From: Jonathan Ng [redacted]
Sent: 18 February 2019 09:47
To: Charlotte Easton
Cc: Ian Haywood
Subject: RE: BR/18/19/PL - South Bersted Primary School

Fig. No. 5 Proposed North & South Elevation to New MUGA Pitch

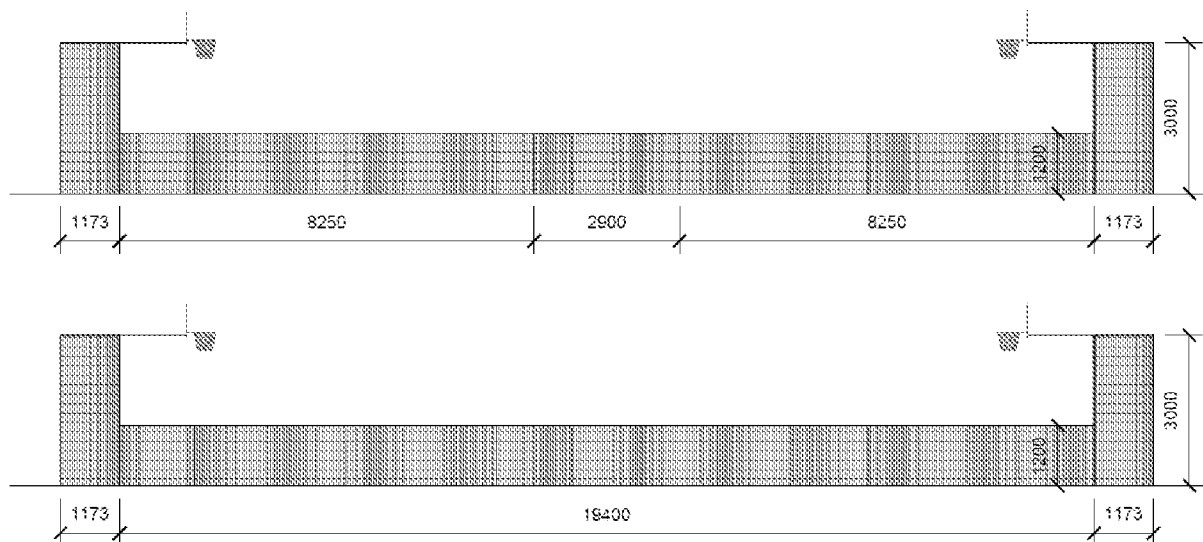
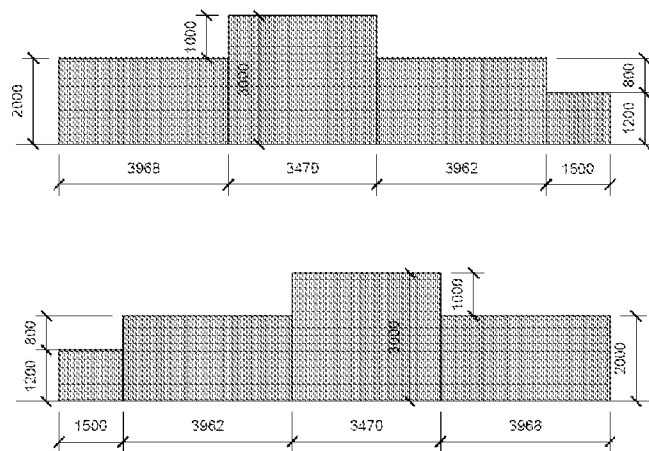
In order for Environmental Health to provide a formal reply, please may the applicant/agent confirm what consideration has been given to the increased noise from the MUGA (specifically, the potential for rattling of the new fencing) and whether the area will be used outside of school hours and/or term time.

Please find attached response from MUGA pitch Suppliers Fawns. The new fencing will have rubber inserts inside the clamp bar fixings, thus preventing any potential for rattling between its parts. The fencing itself is a metal mesh that has a minimum amount of drag, allowing the wind to pass through easily.

With reference to your question regarding excessive noise from the muga at South Bersted School. As standard to reduce this we use rubber inserts inside the clamp bar fixings.
If you would like to discuss further, please do not hesitate to contact me.
